APPENDIX B: SUBMISSIONS

**Western Coal Services Project (SSD 5579 MOD 1)
Response to Submissions**

**Western Coal Services Project (SSD 5579 MOD 1)
Comment on the Statement of Environmental Effects**

**WESTERN COAL SERVICES PROJECT - STATE SIGNIFICANT DEVELOPMENT SSD
5579, MODIFICATION 1, CASTLEREAGH HIGHWAY, LIDSDALE**

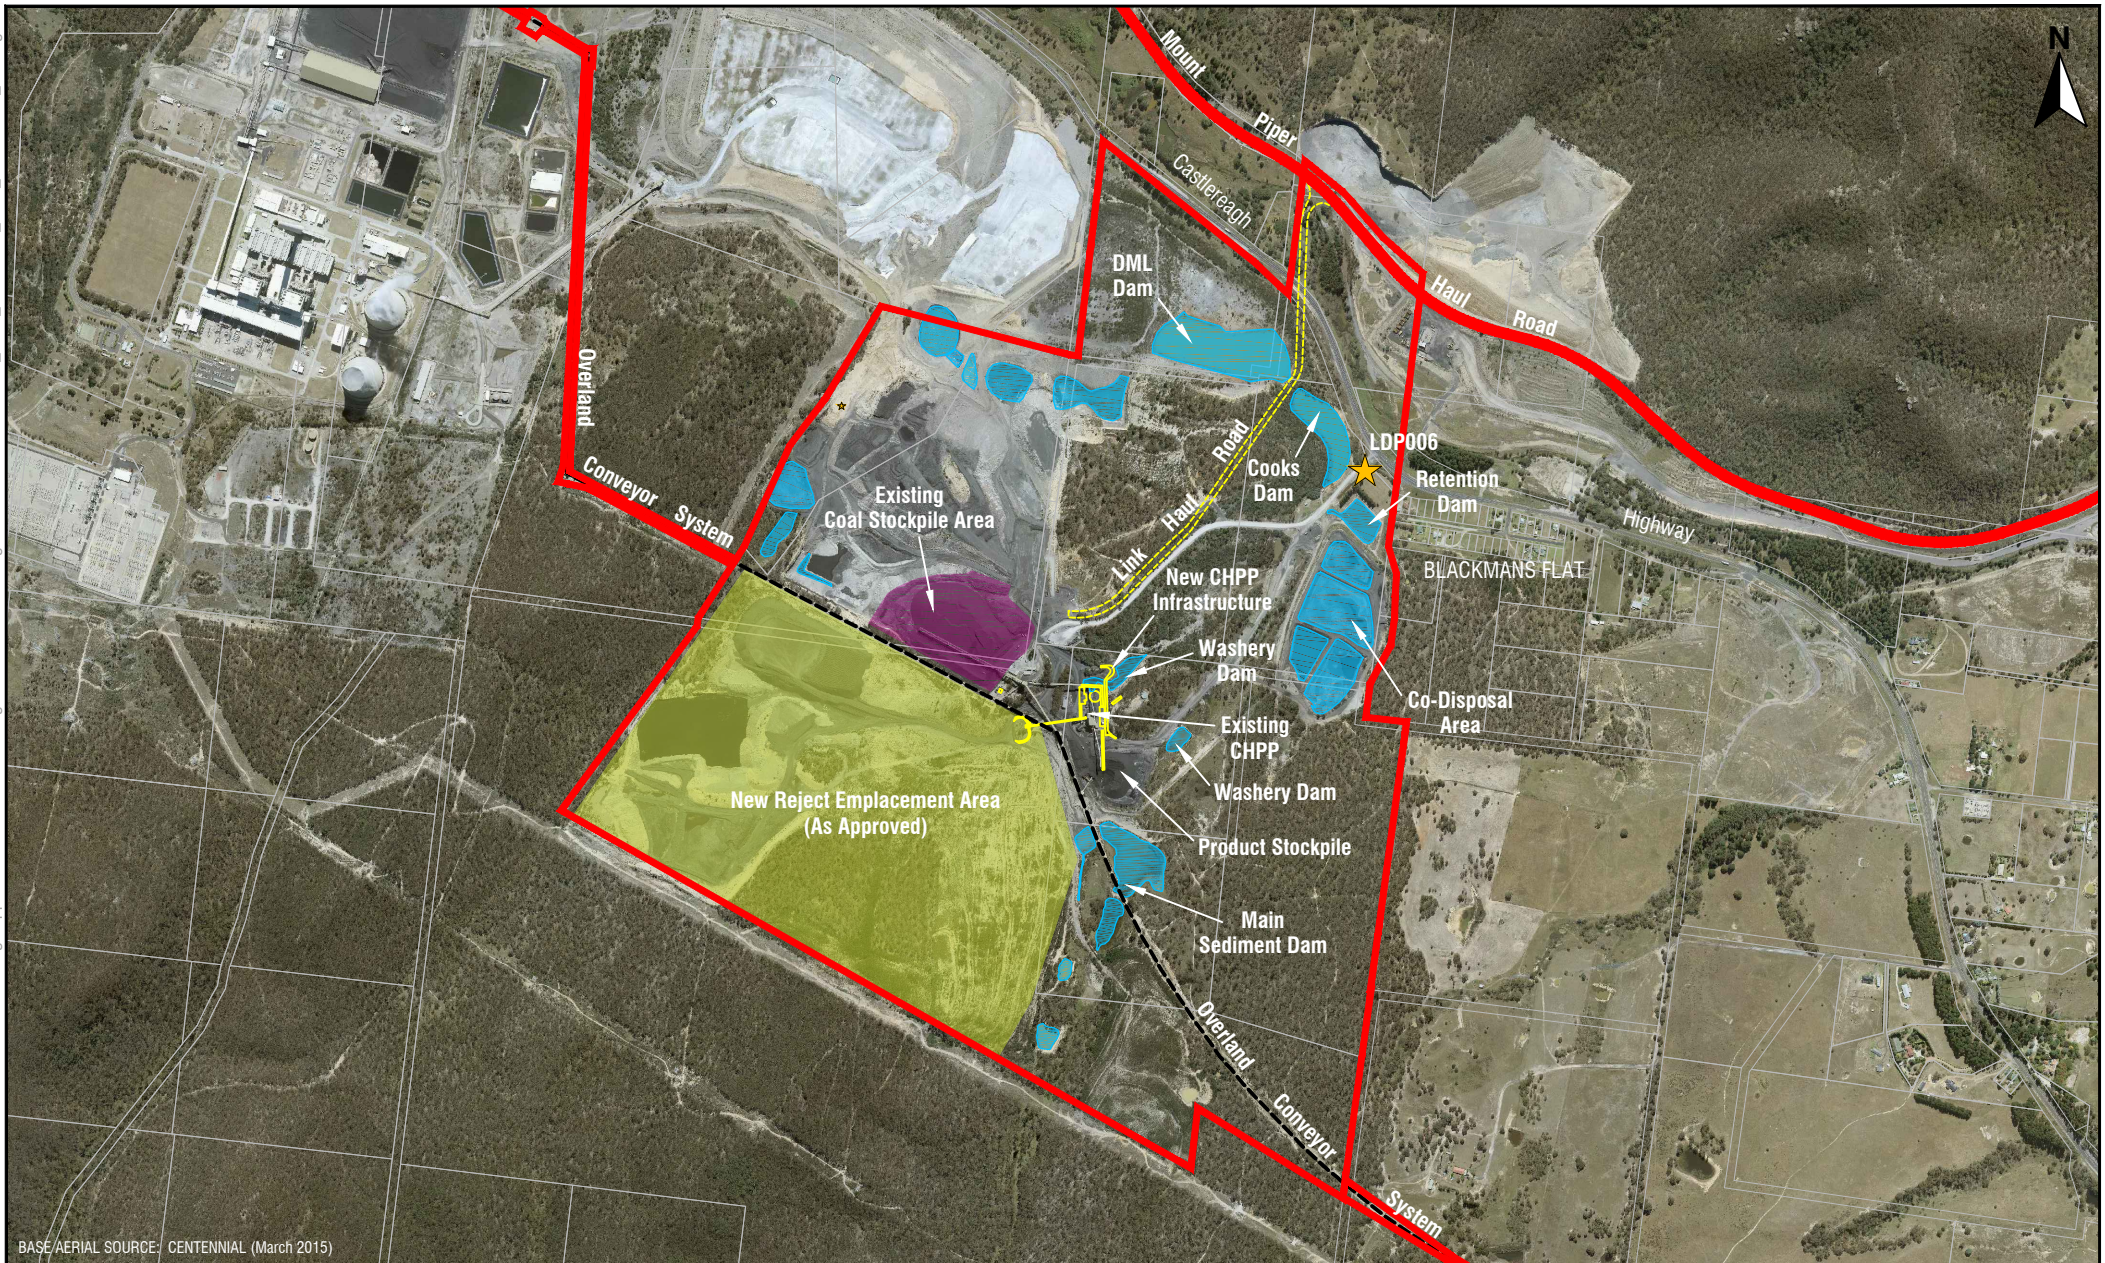
In addition, the EPA is seeking clarification on the exact location proposed for disposal of the residuals. Figure 5 of the main report titled '*Springvale Coal Services Site Infrastructure*' shows the Co-disposal REA located near the main entrance on the eastern side of the site. Whereas, Figure 11 of the main report titled '*Residuals Transfer Pipeline at Springvale Coal Services Site*' shows the Residuals Transfer Pipeline terminating at the REA located on the southern boundary of the site.
